COUNTY COUNCIL'S RESPONSE TO CONSULTATION ON THE FOLLOWING DEVELOPMENT PROPOSAL

Application No: 18/00484/OUT-2

Proposal: Outline planning permission for up to 75 homes, pedestrian and cycle routes, creation of new access point from Charlotte Avenue, provision of open space, play space, allotments, orchard, parking and associated works.

Location: Land North And Adjoining Home Farm, Banbury Road, B4100, Caversfield.

Fig 5.1 - Access and Movement Parameter Plan

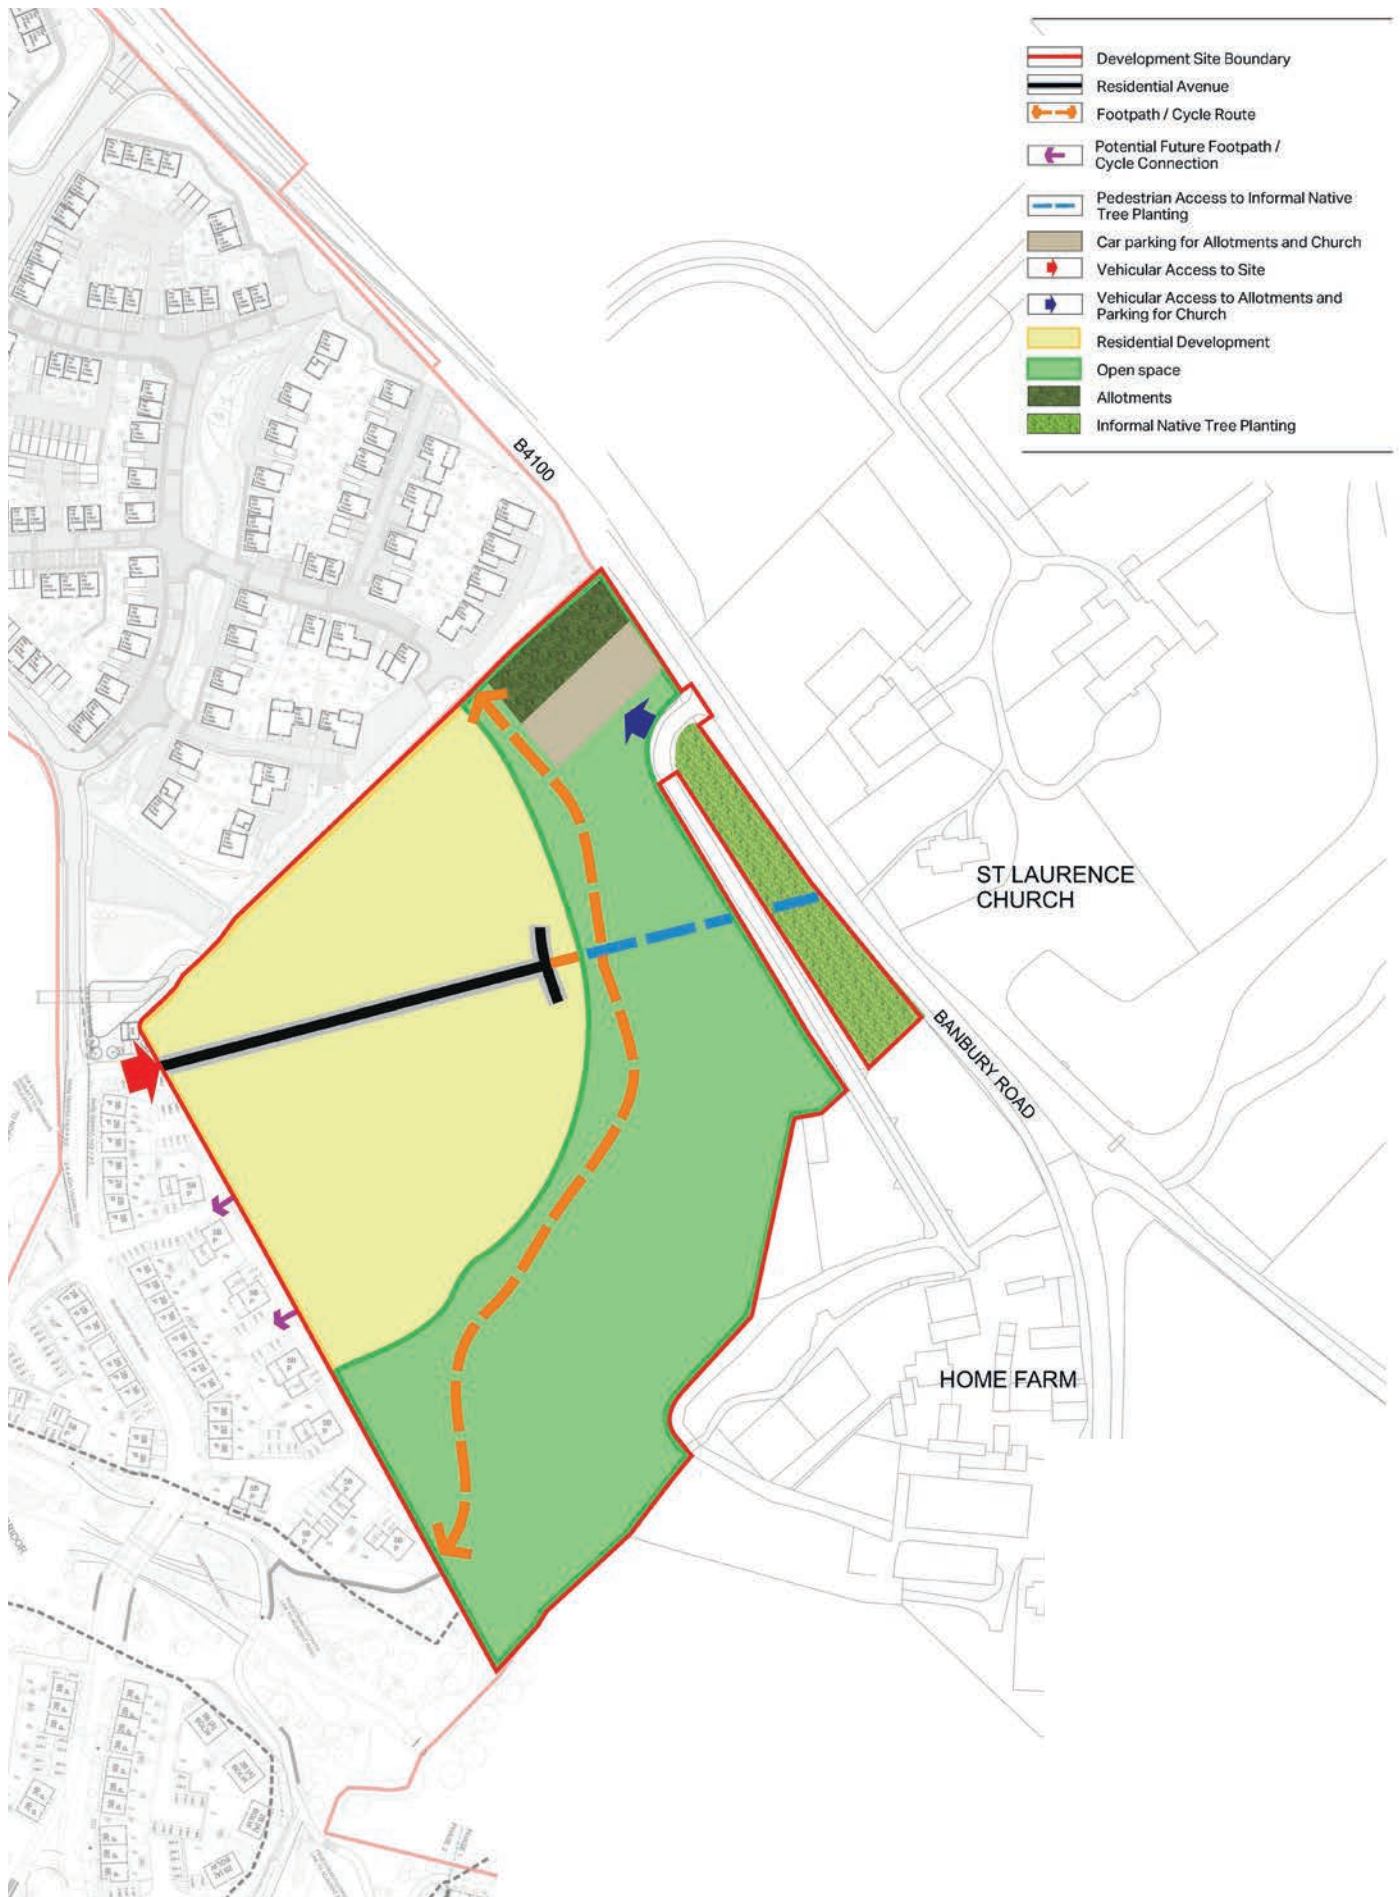
The Updated Access and Movement Plan shows additional pedestrian and cycle access points, which are welcomed, but describes these as 'potential future footpath/cycle connection points'. It is not clear what work has been done to secure these connection points with the adjacent sites. To ensure that they are secured, the wording on the Plan should be amended to remove the words 'potential future'. I note that a path has been included along the western boundary of the site on the illustrative masterplan, which will further assist with connectivity.

Prior to the commencement of the development hereby approved, full details of the pedestrian and cycle connections including the off carriageway pedestrian/cycle route through the site, the pedestrian link between the site and Caversfield Church, and linkages to existing facilities on adjacent parcels, which shall include construction, layout, surfacing, drainage and lighting, together with a timetable for their implementation, shall be submitted to and approved in writing by the Local Planning Authority. Thereafter the pedestrian/cycle route and links shall be constructed in accordance with the approved details and the approved timetable.

Fig 7.2 - Tree-Lined Avenue

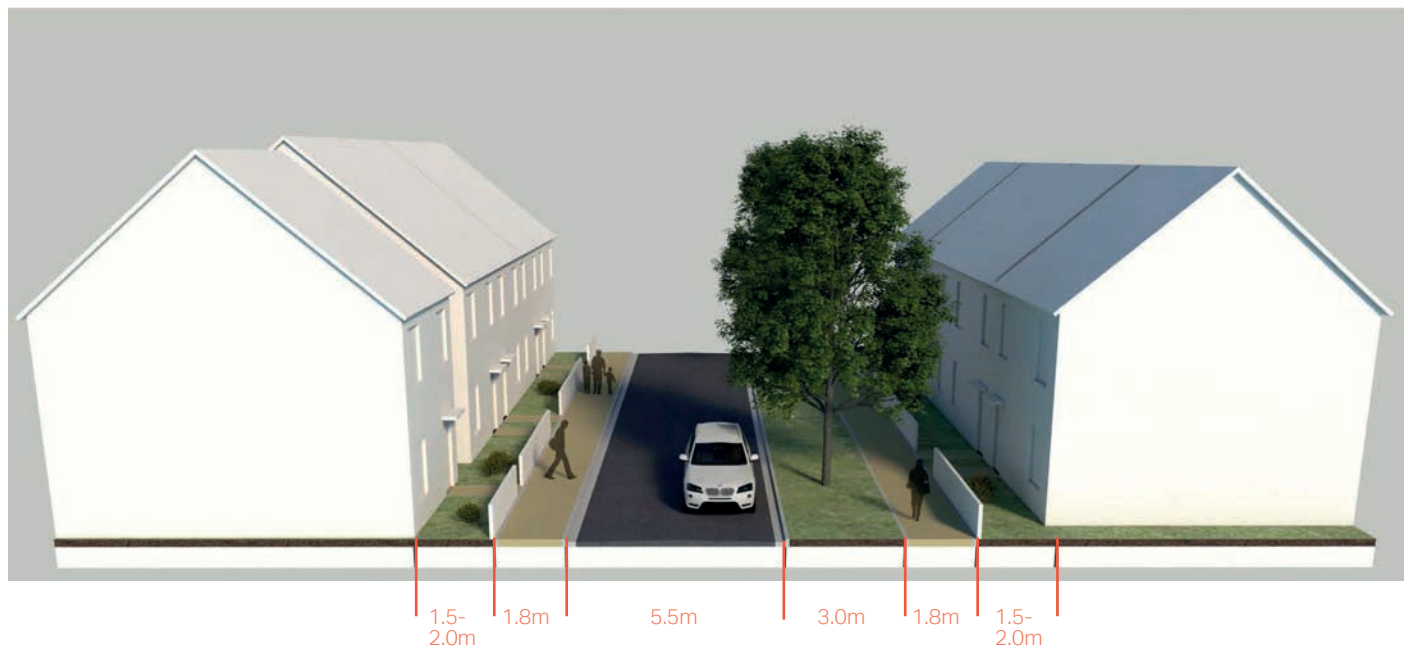
As this is an outline planning application, I have not reviewed the indicative layout in detail. However, there are a few aspects of the Design and Access statement where further advice from the Highway Authority should be sought, particularly in relation to adoptability. These include:

- Tree planting along the tree-lined avenue
- Parking on the tree-lined avenue
- Dimensions of low key access roads
- Types of lighting
